RESPONSE TO DEADLINE 2 COASTAL DEFENCE SUBMISSION [REP2-116](#) AND ONE DIMENSIONAL MODELLING OF SOFT COASTAL DEFENCE [REP2-115](#)

MINSMERE LEVELS STAKEHOLDERS GROUP (MLSG)

Representation

DRAWING NO: SZC-SZ0100-XX-000-DRW-100262	REVISION: 01
DATE: JUNE 2021	DRAWN: CK
SCALE: AS SHOWN @ A1

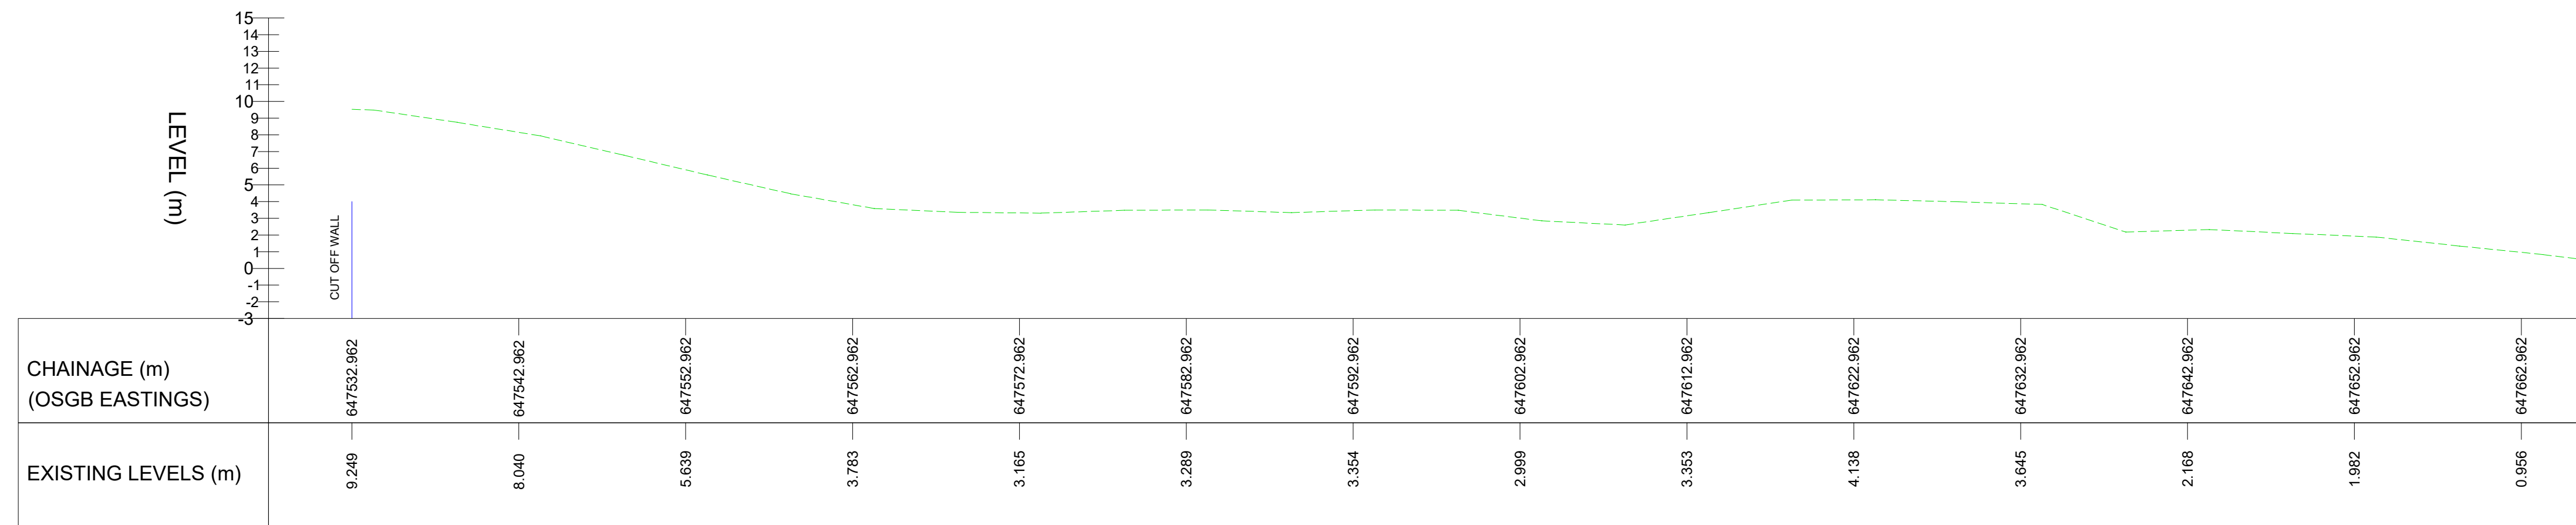
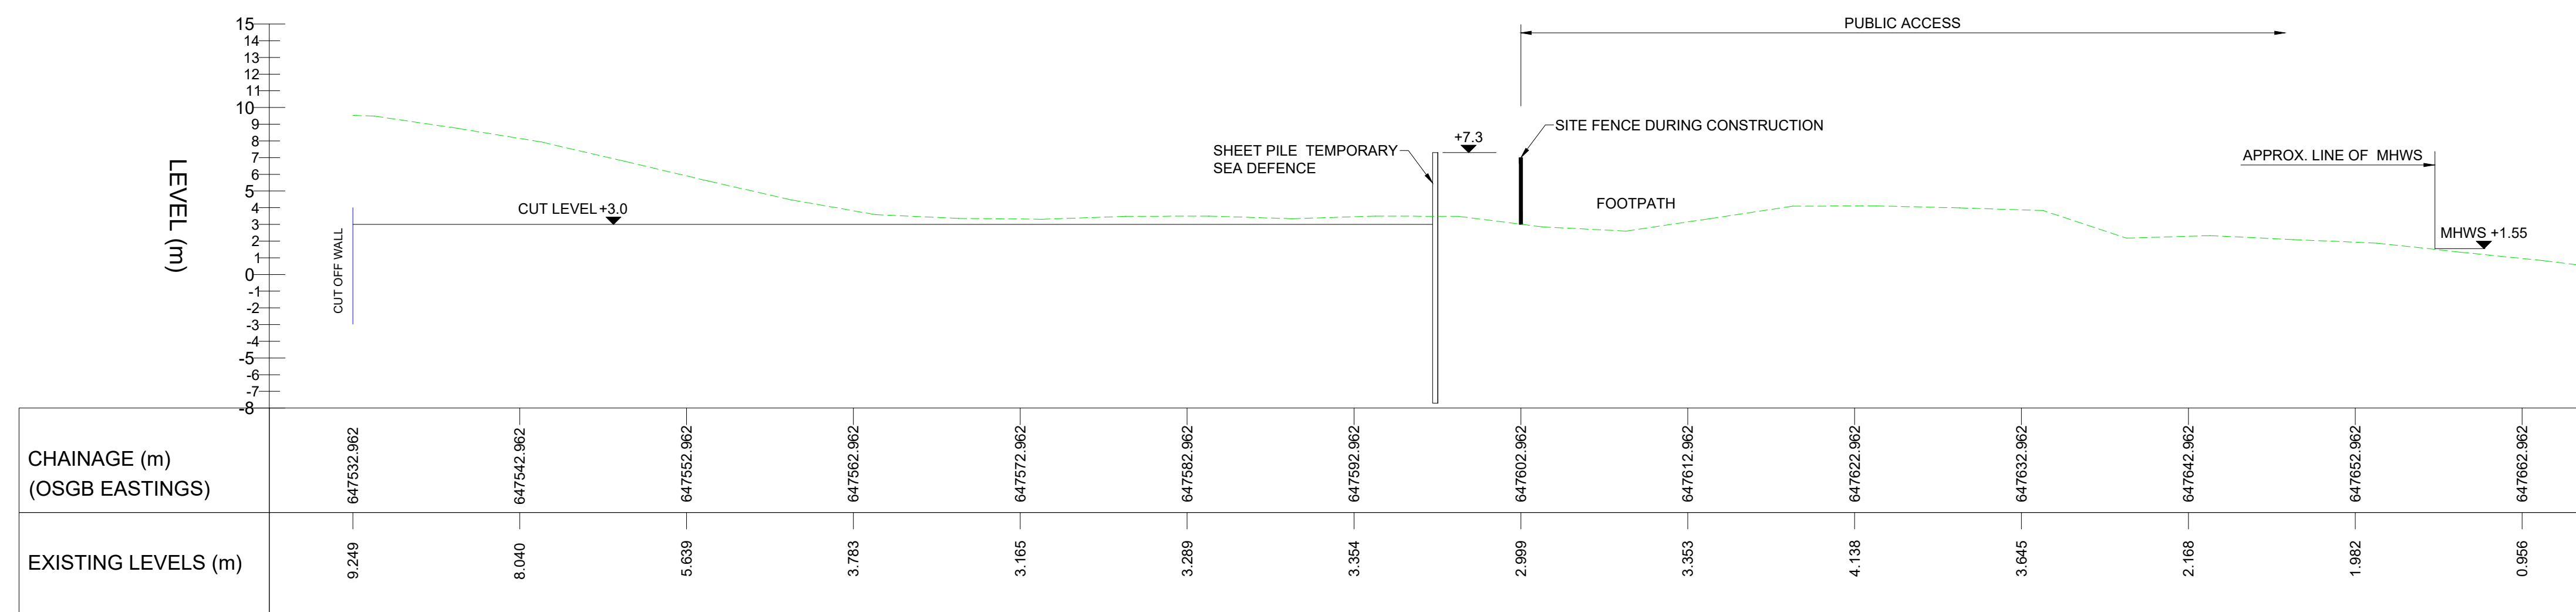
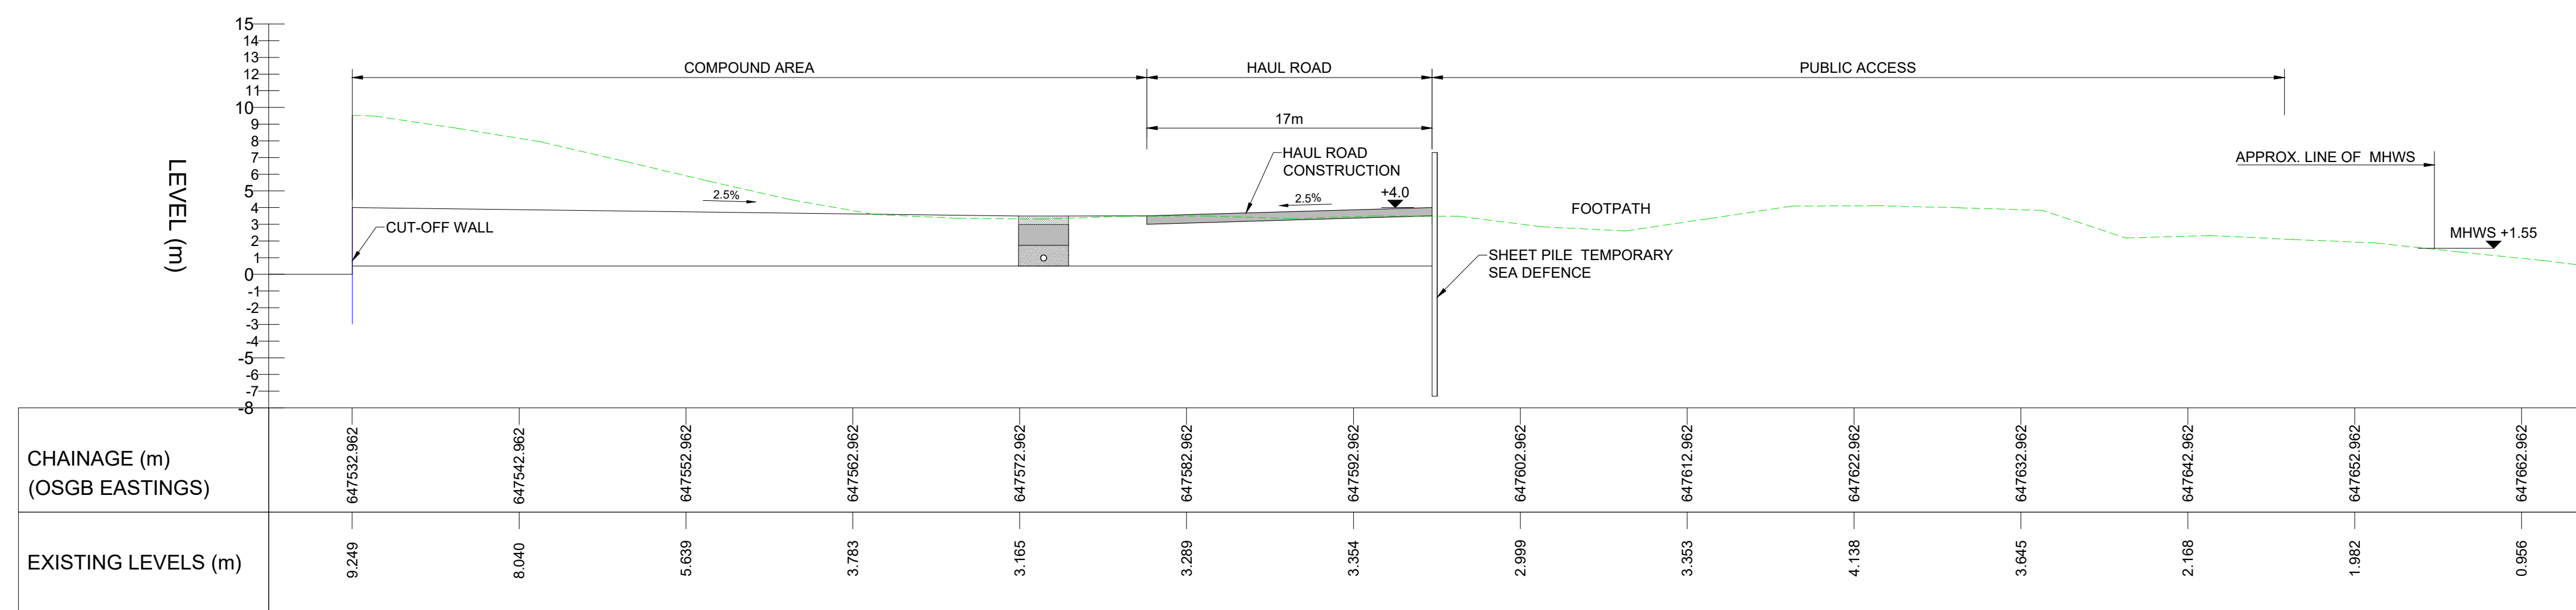
MLSG is still concerned that details requested for the design and implementation of the HCDF in our written representation ([REP2-377](#)) have not been submitted. A single cross-section has been selected specifically to avoid potential impacts of cooling tunnel access shafts on unclear ground improvement works along the entire length of the HCDF.
